# Council for British Archaeology

8<sup>th</sup> February 2019

**Duke of York Inn, Grindleton Brow, Grindleton, Clitheroe, Lancashire, BB7 4QR. Application No. 3/2019/0050**

FIRST FLOOR PLAN

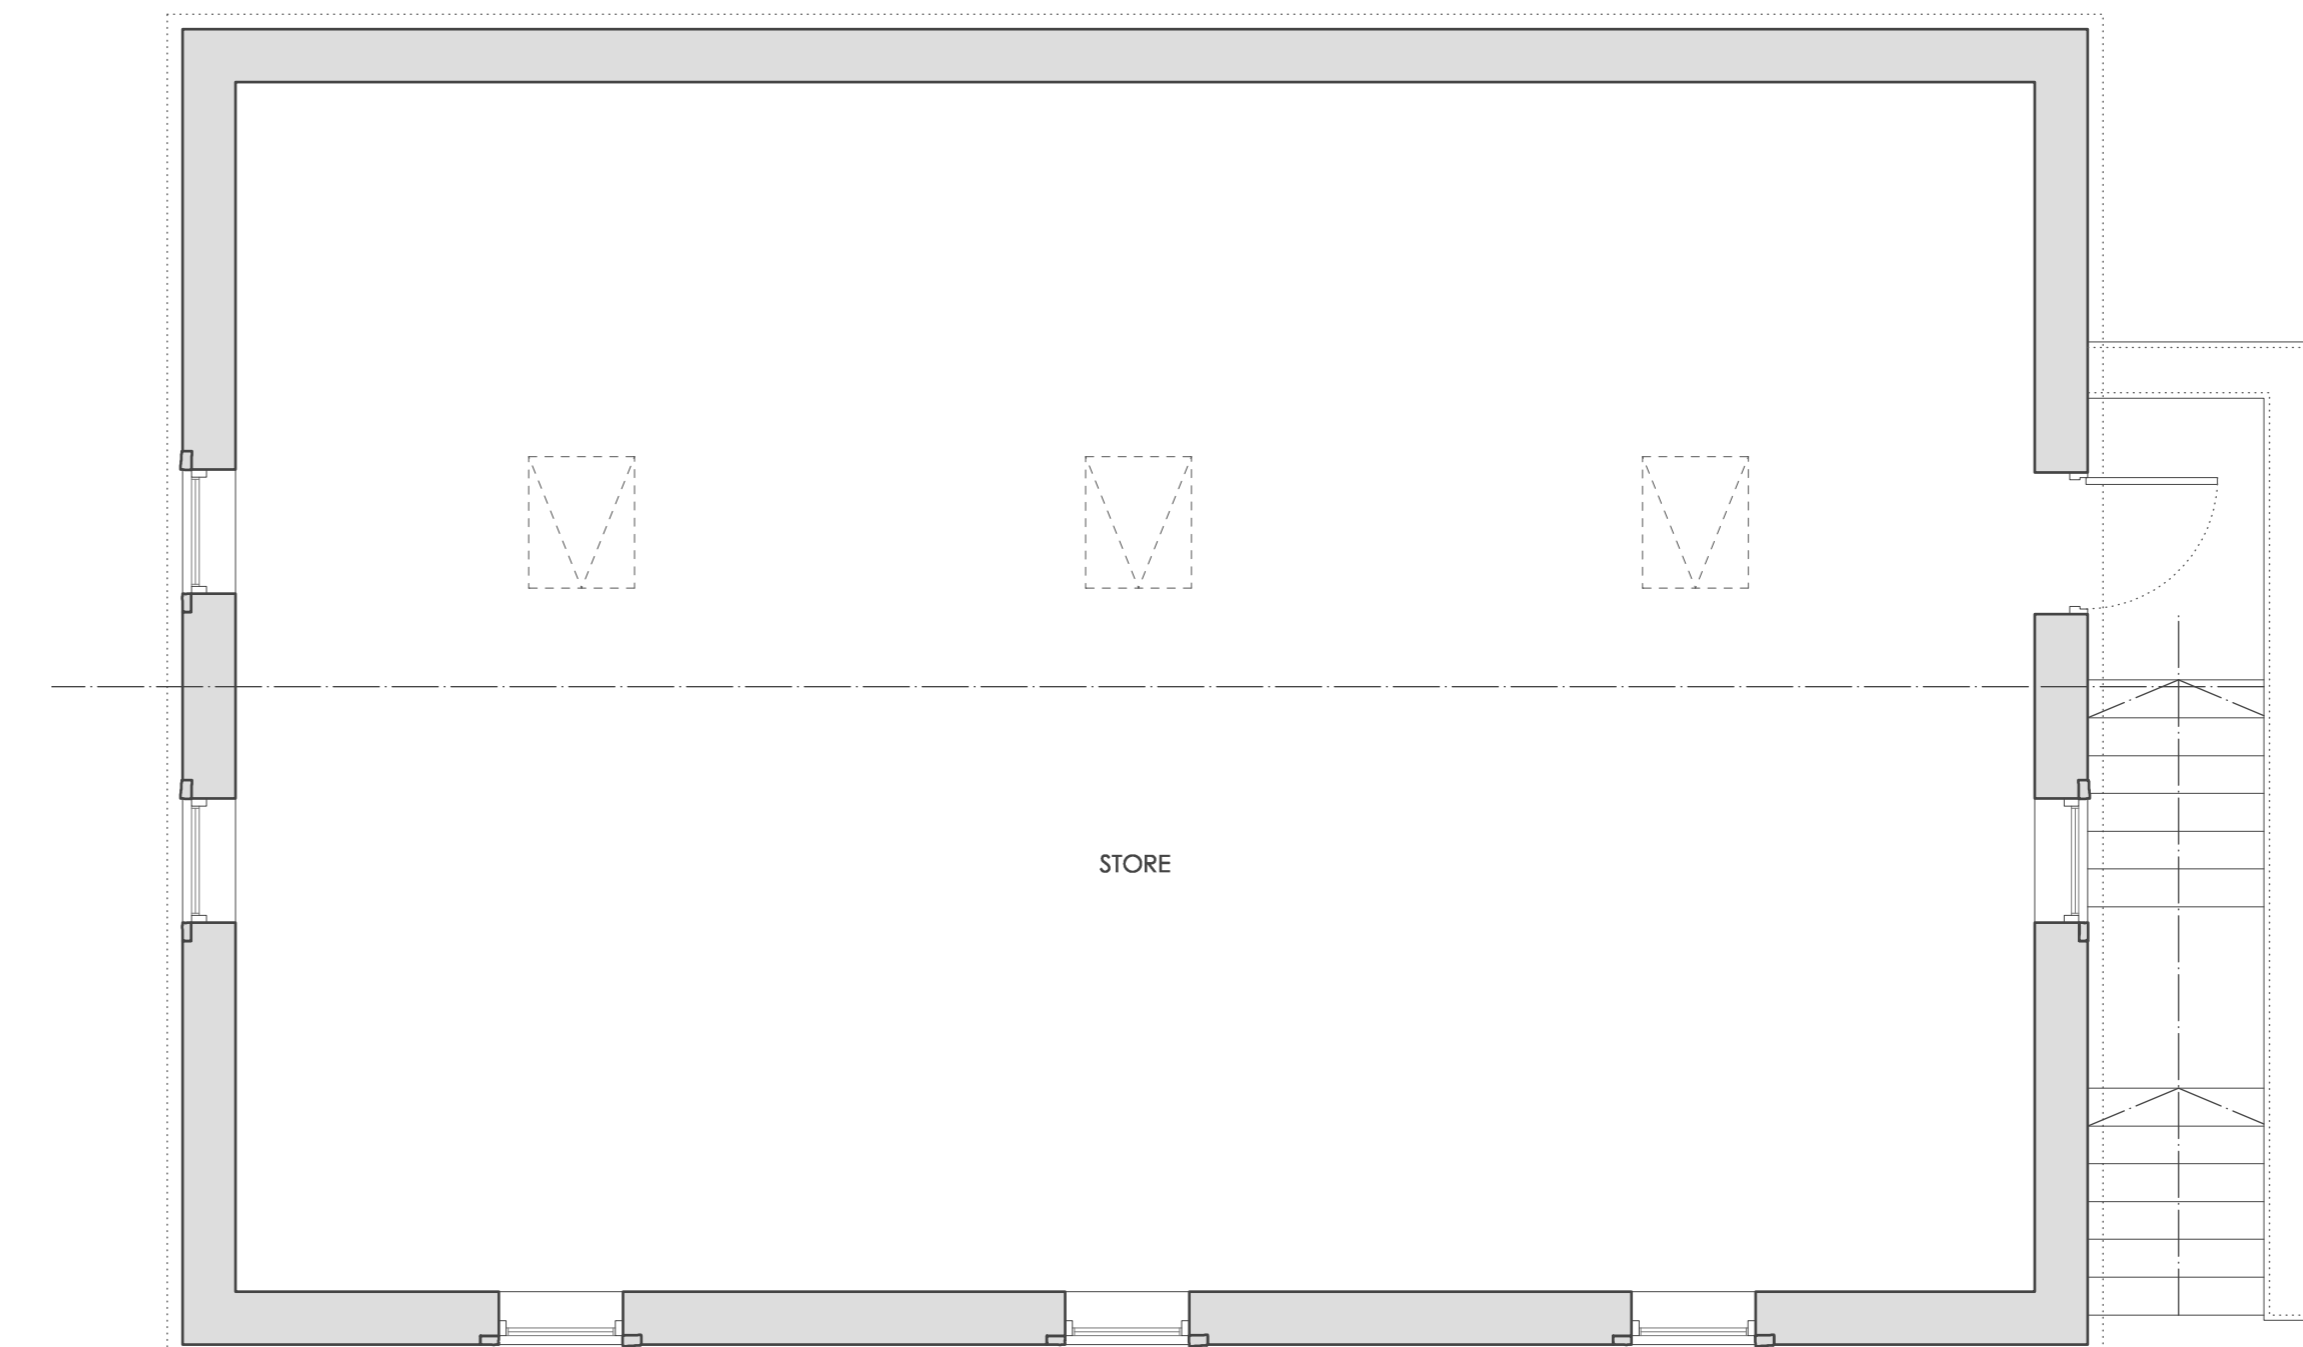
Having examined the plans, elevations and single visualisation for the proposed new builds and associated access, landscaping and garaging, we conclude that the proposed cottages and associated works will result in a substantial change to the setting of both the Listed Grade II Duke of York Inn and the Grindleton Conservation Area. The setting of the Inn will be heavily compromised by the new frontage building and the redesigned site access. The status of the Inn as a Focal Building at a gateway location to the conservation area will be challenged to the extent that from Brow Hill at least the Inn will no longer 'stand out'. We consider this to be *"harm"* as defined in the NPPF. Whether this impact on the setting of both designated heritage assets would amount to *"substantial harm"* or *"less than substantial harm"* may not be the issue.

The absence of an appropriate assessment of significance notwithstanding, the CBA considers the design, scale and massing of the proposed new builds to be out of character. The main new build against Brow Hill is set forward from the Duke of York Inn and is far too large to successfully respect the character and appearance of the Conservation Area and the setting of the Listed Grade II Duke of York Inn. The proposed gable, for instance, introduces a design element that is not reflected in any other buildings within the immediate area.
